**KIRKLEES METROPOLITAN COUNCIL  
INVESTMENT & REGENERATION SERVICE**

**DELEGATED DECISION TO DETERMINE PLANNING APPLICATIONS**

Reference No:	<b>2024/62/90146/W</b>
Site Address:	4, Roman Avenue, Mount, Huddersfield, HD3 3XP
Description:	Erection of single storey rear extension and raised patio
Recommending Officer:	Molly Storer

## HOUSEHOLDER DELEGATED REPORT

No.	Date	Dr	Description
scale	As indicated	drawn	PSI
date	JAN 2024	checked	LG
status			PLANNING
job no	2307	dwg no	A(10)-01

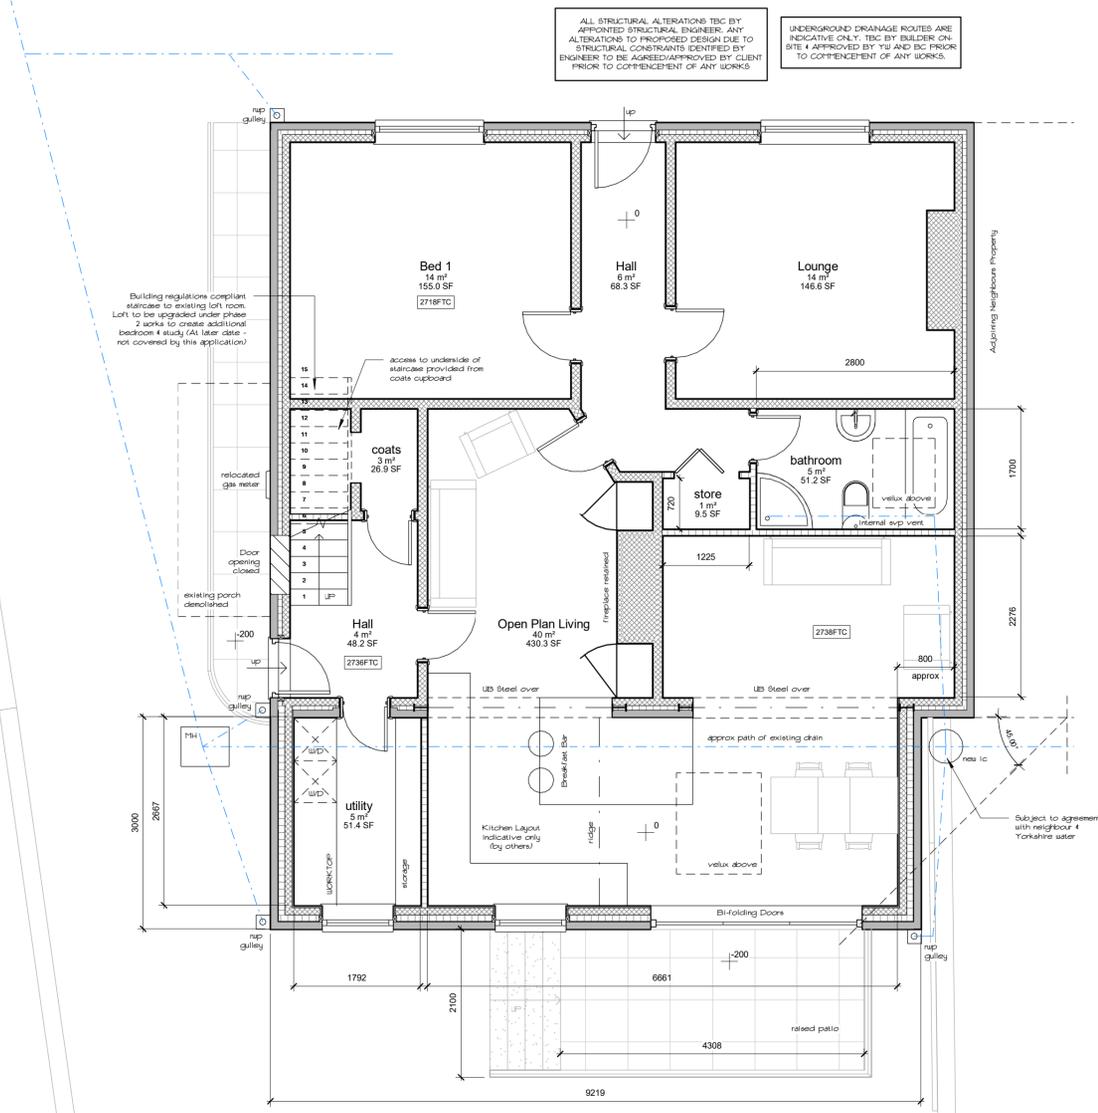
Negotiations/Amendments during course of application	Yes	Amendments sought to move the extension away from the neighbouring boundary and to ensure that the 45 degree angle is not cut to be SPD compliant. The agent submitted plans that showed the extension to retain a gap of 1.2m between the extension and the boundary, which officers considered to be acceptable.
Parish/Town Council comments sought	No	
Planning History	No	
Consultations required	No

where they exceed 3m in length the eaves height should generally not exceed 2.5 meters	The extension would not exceed 3 metres in projection.	N/A
retain a gap of at least 1 metre from a property boundary, such as a wall, fence or hedge.	Amended plans show that the extension will retain a gap of 1.2m from the property boundary. This is considered acceptable by officers.

No.	Date	Dr	Description	drawn	check	approved
As indicated		PSI				LG
date	JAN 2024		G:\Architectural\Jobs\2307 - Gen. Marsh\Arch\Proposed\2307 - proposed\PLANNING\RevA.rvt			
status			PLANNING			
job no	2307	dwg no	A(10)-01	rev		A

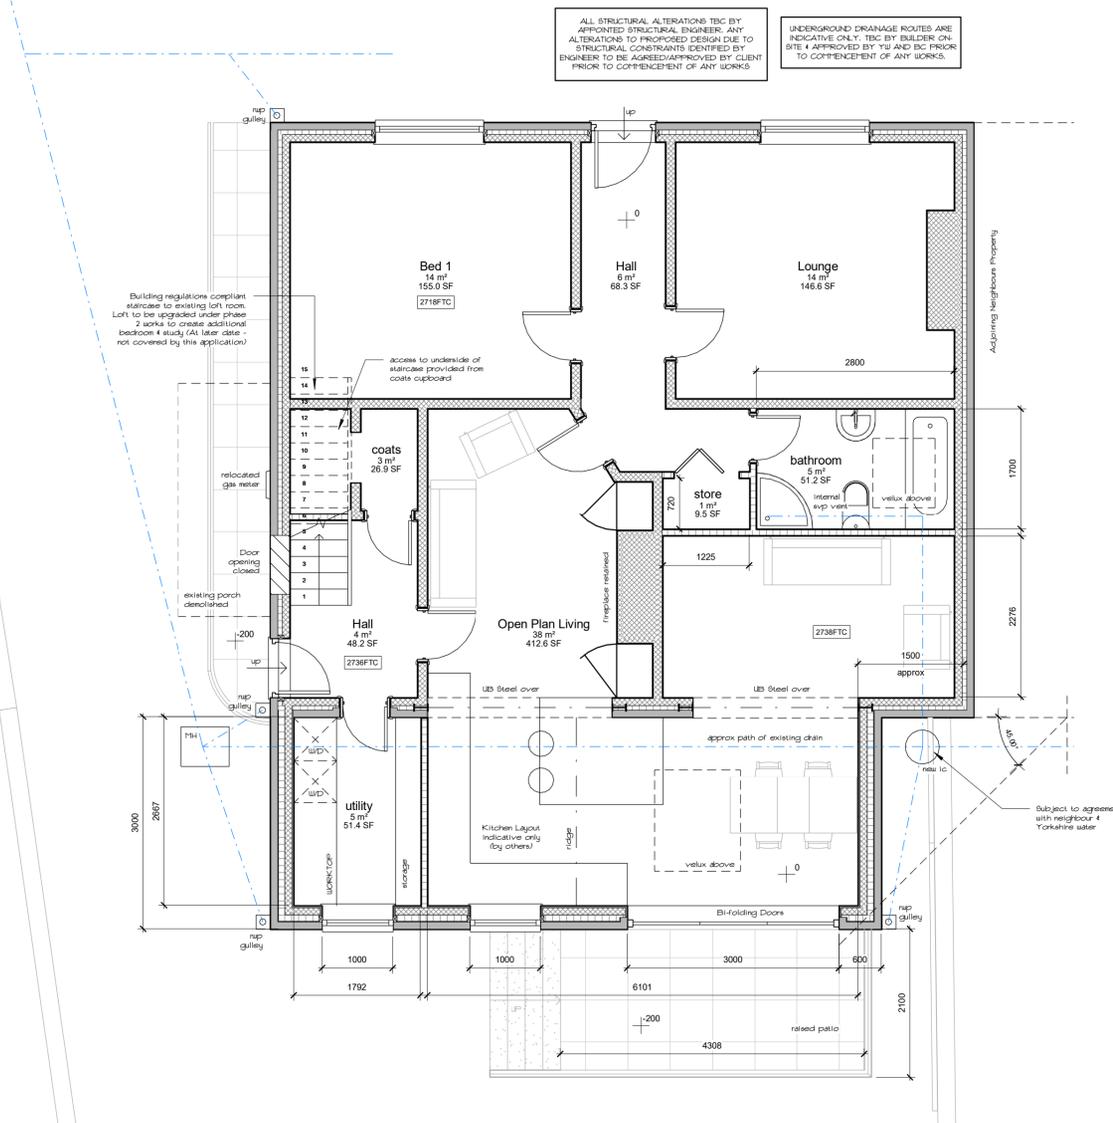
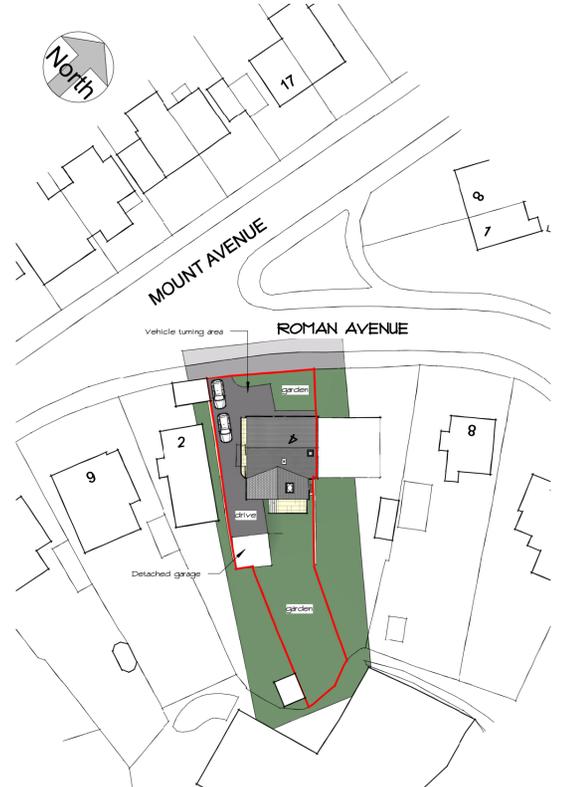
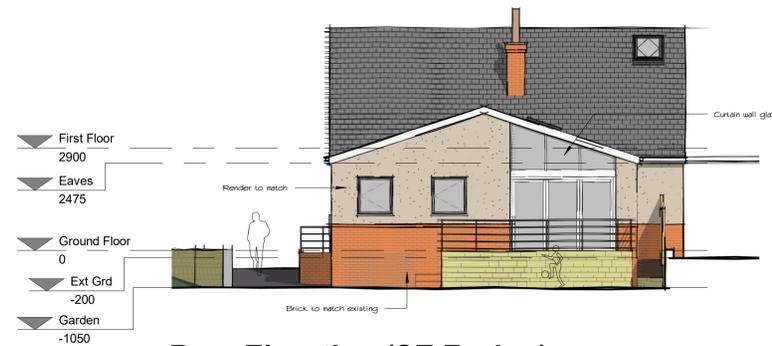
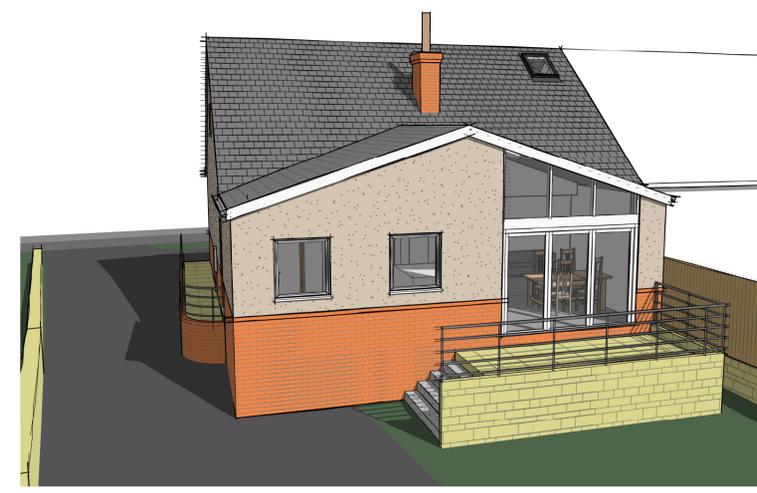
<b>Relevant key design principle (KDP) of the SPD, Policy in the Kirklees Local Plan and the NPPF</b>	<b>Further comments</b>	<b>✓ / X / N/A</b>
Impact on privacy of neighbours (to sides, rear and front)	<ul style="list-style-type: none"> <li>• KDP 3 &amp; 4 of the SPD</li> <li>• Policy LP24 Design (d) (iv)</li> <li>• Chapter 12 of the NPPF</li> </ul>	The proposed rear extension does not have any windows within its side elevation facing 6 or 2 Roman Avenue therefore privacy would be maintained for these neighbours. In regard to the raised patio separation distances between this and the neighbouring properties will provide additional privacy, with existing fencing shown retained between nos. 6 and the application site.	✓
Impact on light and outlook of neighbours (to sides, rear and front)	<ul style="list-style-type: none"> <li>• KDP 4, 5, 6 of the SPD</li> <li>• Policy LP24 Design (b)</li> <li>• Chapter 12 of the NPPF</li> </ul>	The amended plans show the extension to be 1.2 metres off the shared boundary. Therefore, although the orientation of the dwellings will result in some shadowing in the afternoons it is considered that this gap will limit any shadowing that may take place. Furthermore, placement of the extension only narrowly cuts the 45 degree angle by 0.4m on balance this is considered acceptable	✓

Pursuant to article 35 (2) of the Town and Country Planning (Development Management Procedure) Order 2015 and guidance in the National Planning Policy Framework, the Local Authority have, where possible, made a pre-application advice service available, complied with the Kirklees Development Management Charter 2015 and otherwise actively engaged with the applicant in dealing with the application. Officers sought for a gap to be maintained from the rear extension to the boundary, as the it was considered that the extension being built up to the boundary would cause undue residential impact to the neighbouring property. Amended plans were submitted retaining a gap of 1.2 metres as suggested by officers.
